# CITY OF ALBUQUERQUE

**RE: Anthea – 4<sup>th</sup> and Granite NW  
330 Granite NW  
Request Permanent C.O. - Accepted  
Engineers Stamp Date 9/12/14 (J14D171)  
Certification Dated: 8/28/15**

**Re: Anthea – 4<sup>th</sup> at Granite  
Grading and Drainage Plan  
Engineer's Stamp Date 9-12-14 (J14D171)**

**Re: Anthea – 4<sup>th</sup> at Granite  
Grading and Drainage Plan  
Engineer's Stamp Date 9-3-14 (J14D171)**

ANTHEA 4TH AND GRANITE
GRADING AND DRAINAGE PLAN
ALBUQUERQUE, NM
PROJECT #14-009

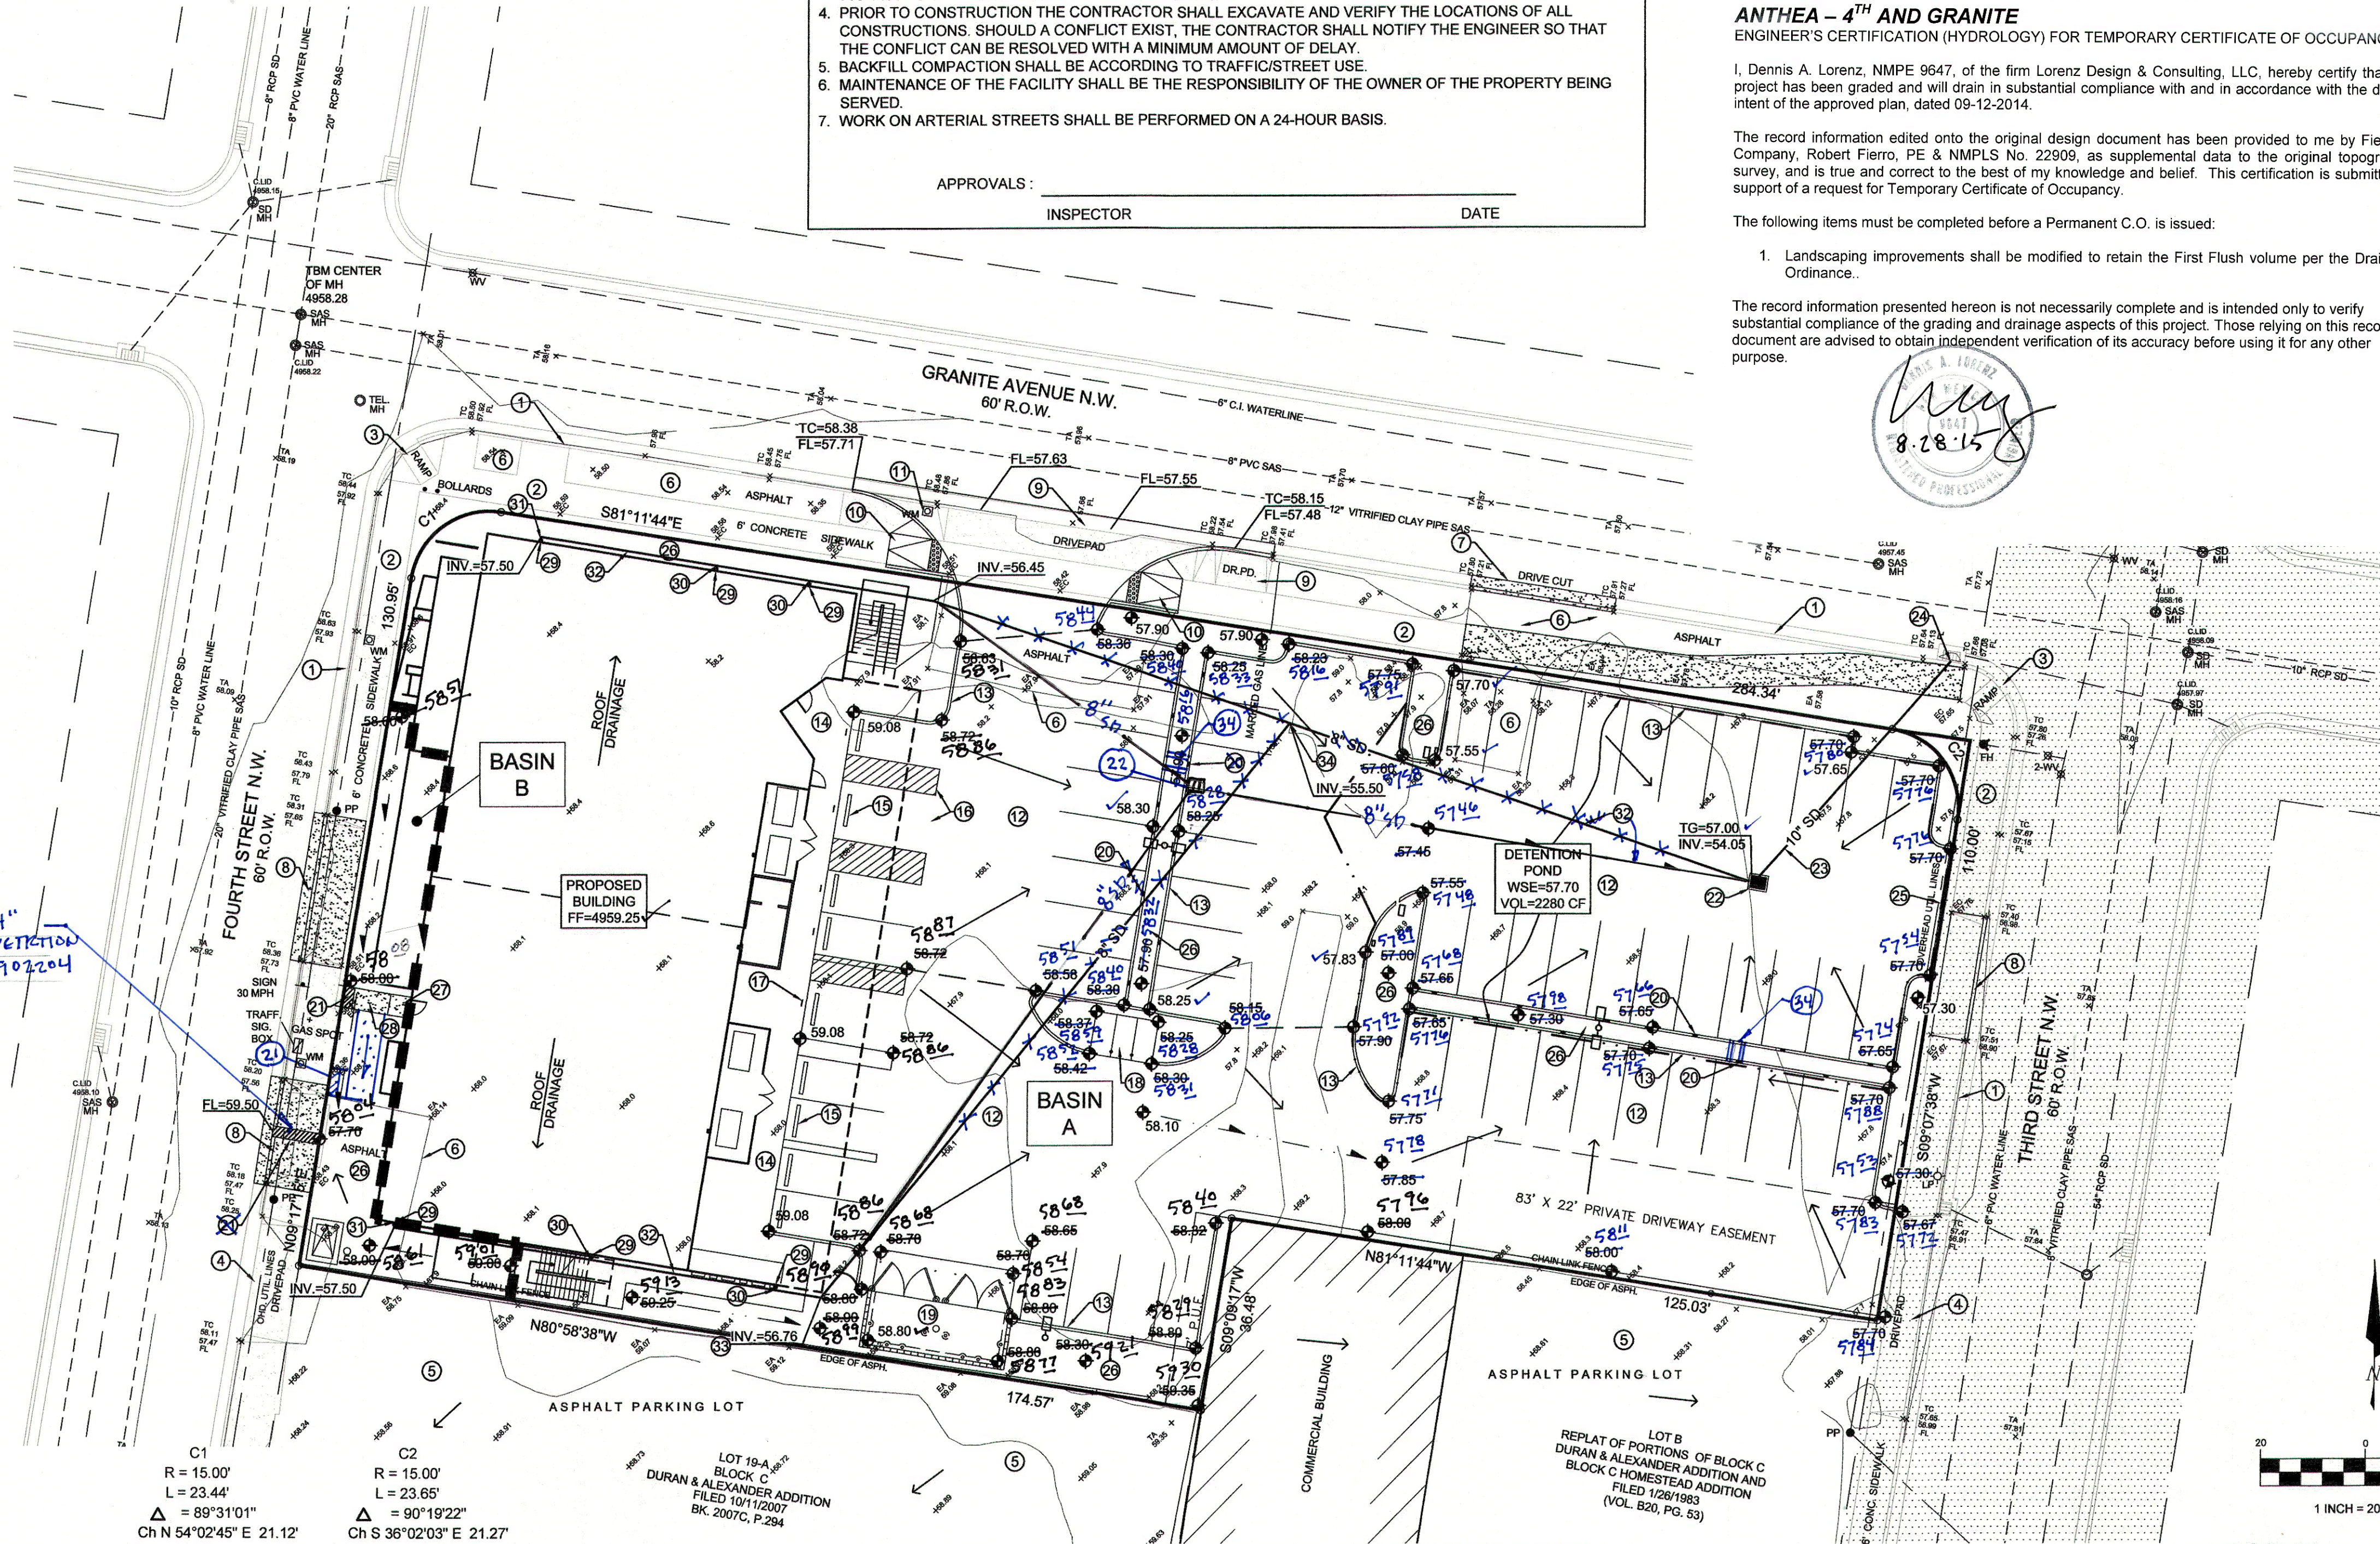
1. The First Flush calculations have a sum for the landscape areas that include all landscape area on site. However, drainage is not being directed into many of those areas. Revise the calculations to only include landscape areas where ponding is occurring. The inlet in the parking lot can be lowered and used for the First Flush also.
2. For the 8 inch storm drain on the northwest side of the building at 58.29, there is only 0.29 inches of cover. Provide more cover. Show an invert for the 8 inch storm drain connection on the south side of the building.

Submitted herewith for approval are two (2) copies of the revised Grading and Drainage Plan and Supplemental Calculations. The plan has been revised to address the comments listed in your letter dated September 11, 2014. Specifically, the following revisions have been made to the Plan:

1. First flush calculations are revised documenting the required and proposed ponding volumes. The first flush ponding areas are limited to those landscaped areas that receive runoff from the paved parking lot. As shown by the calculations, we fall short by approximately 300 cubic feet of volume, however we providing ponding to the maximum extent possible given the site conditions.
2. The storm drain from the building roof drainage system has been re-graded to provide additional cover.
3. Other minor corrections were made per our telephone conversation.

A
C-2.0

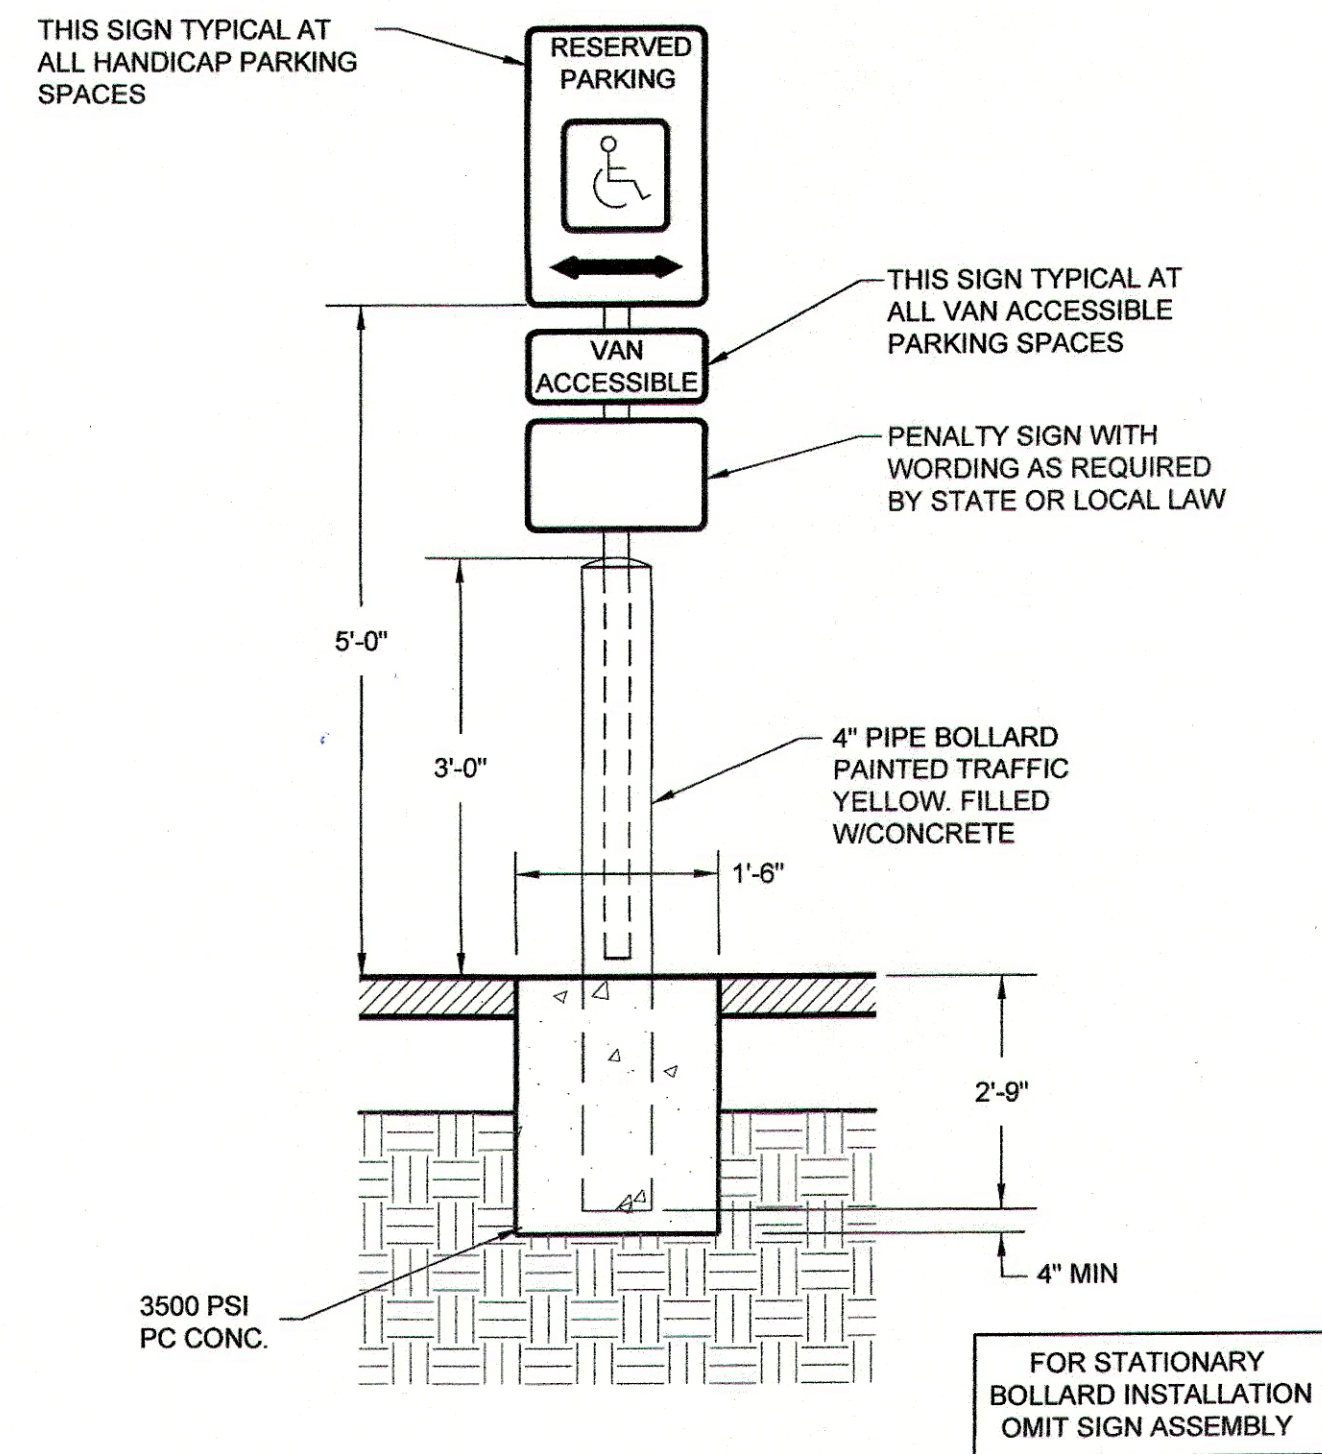
Standard HC Ramp detail? A/C-2.0  
WILL HAVE TO GET EXCAVATING + BLOG PERMIT

POND OVERFLOW WEIR SECTION
NTS

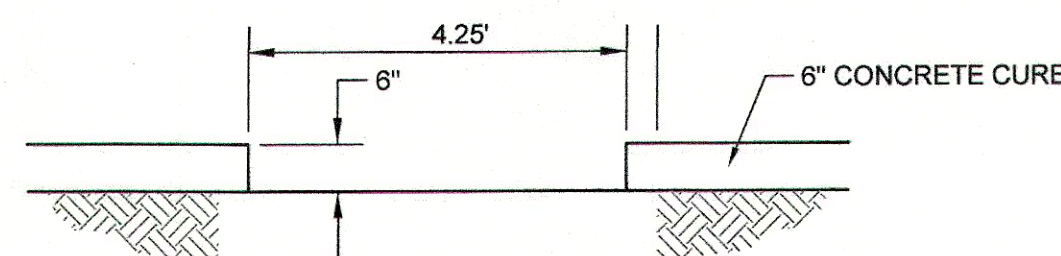
~~Overflow weir detail?~~
